## Letter of Intent

**Subject:** Engineer

**Author:** dsdgrimm

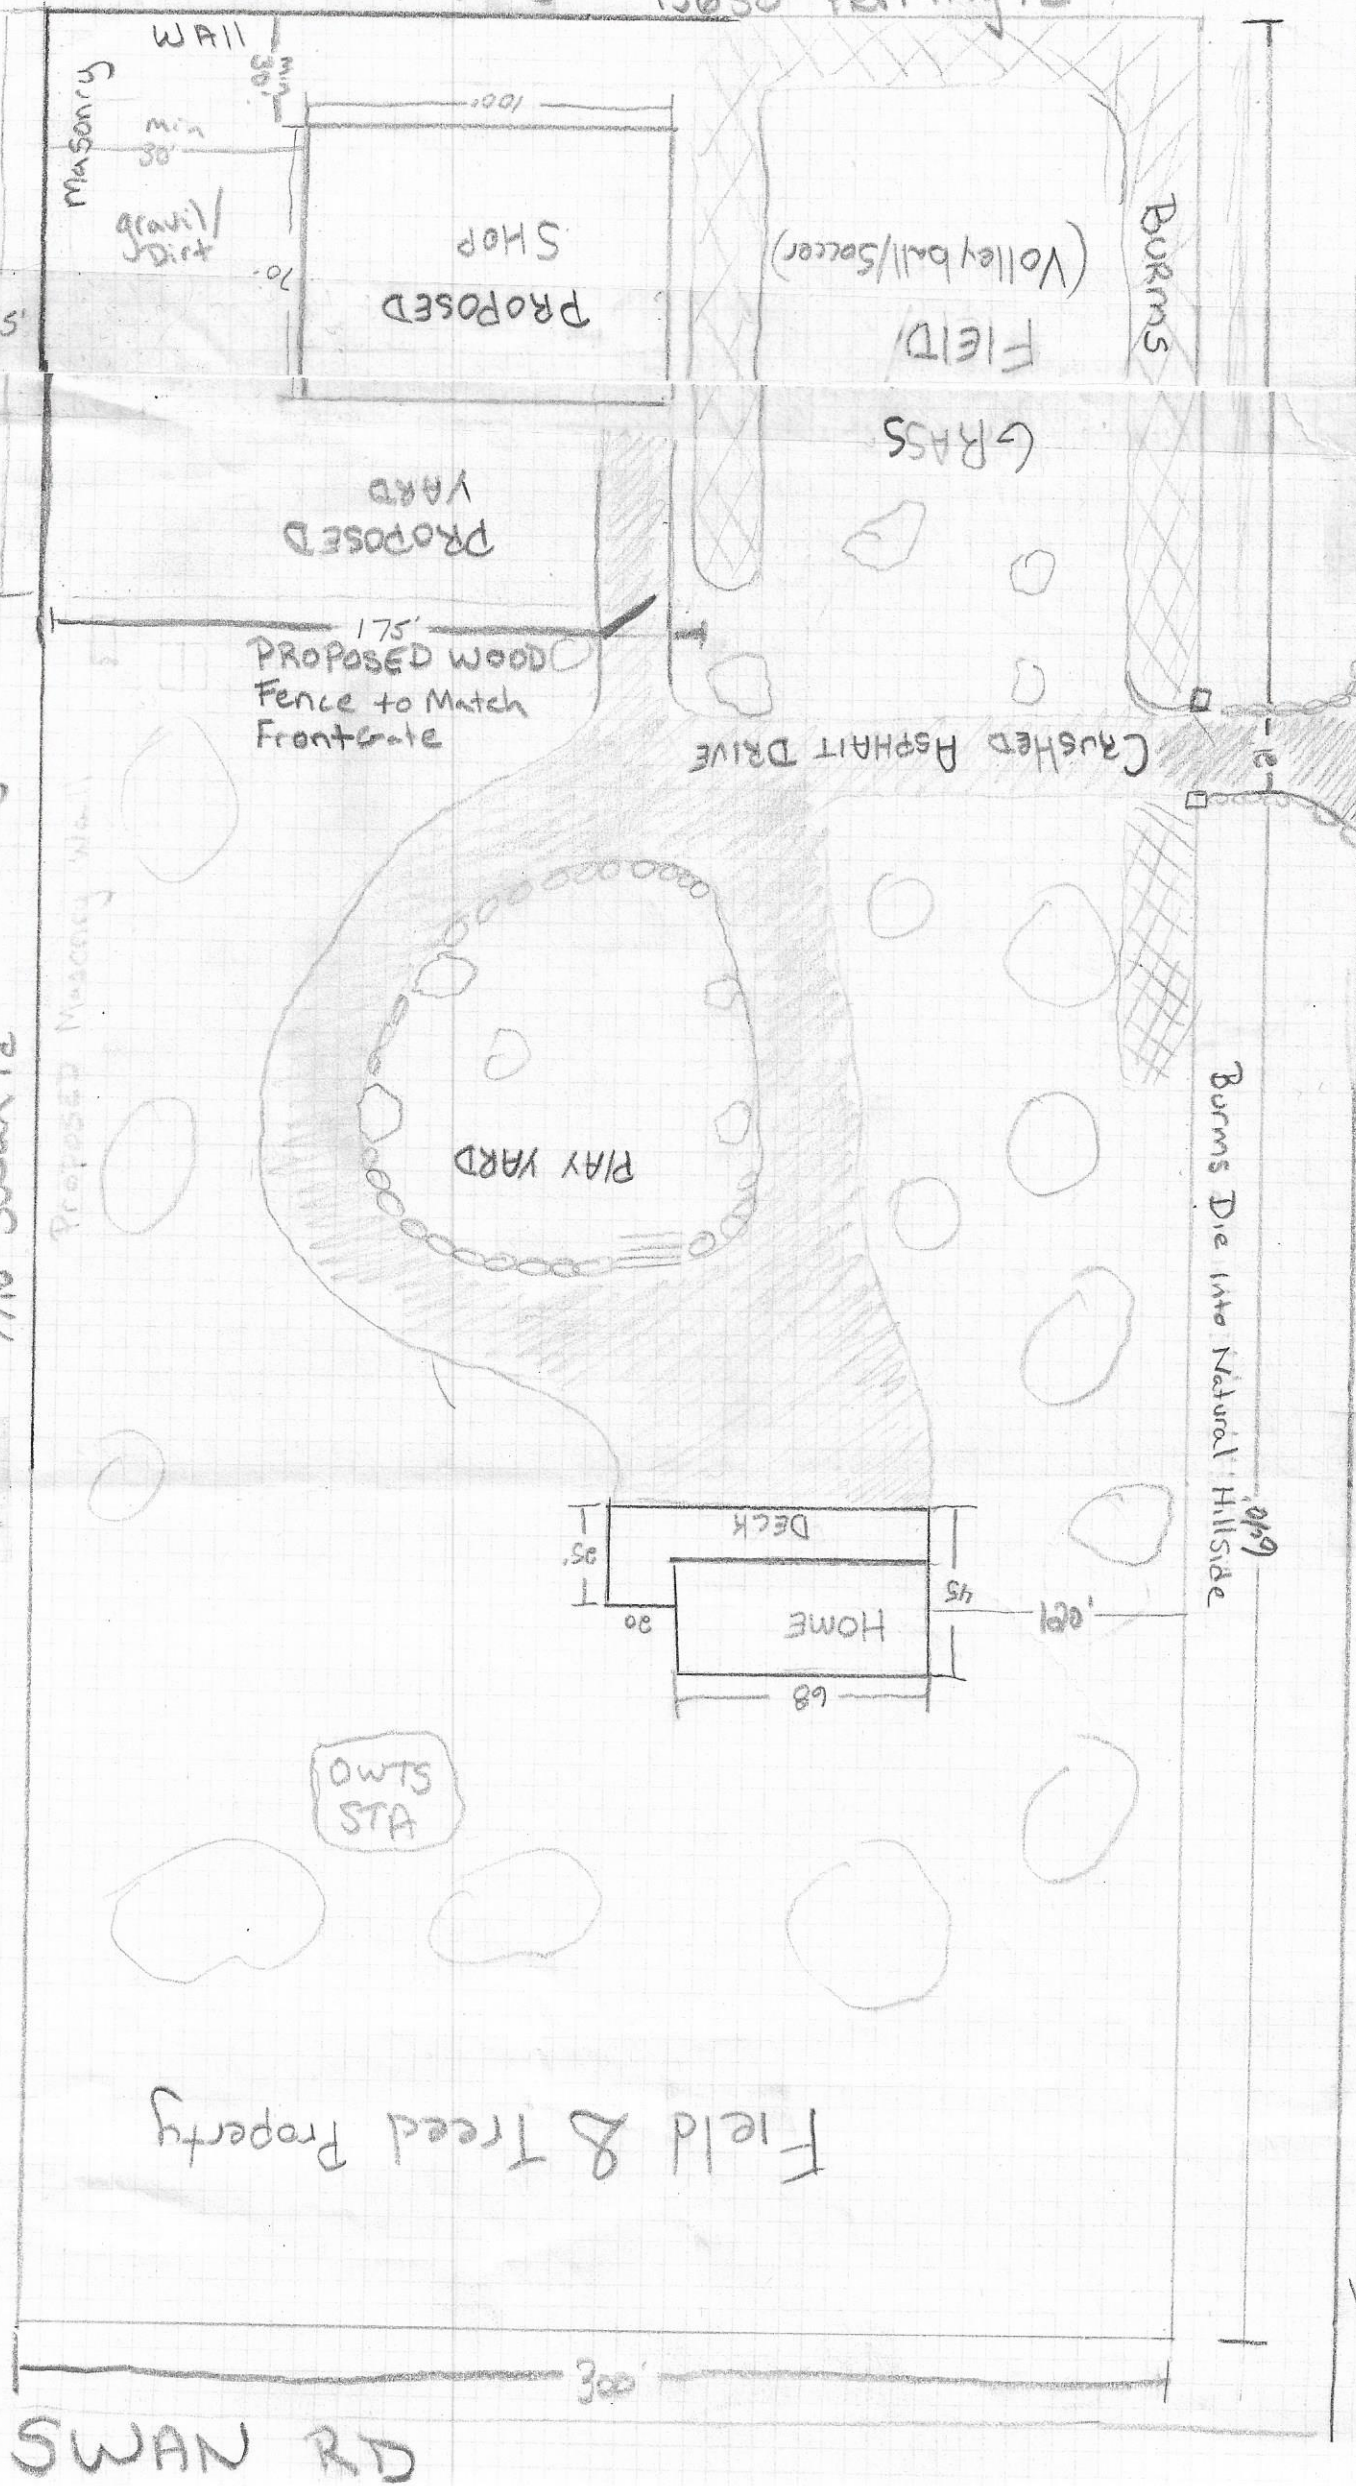
State that the drainage from the proposed structure will not adversely affect the adjacent properties.

State that the drainage from the proposed structure will not adversely affect the adjacent properties. (1)
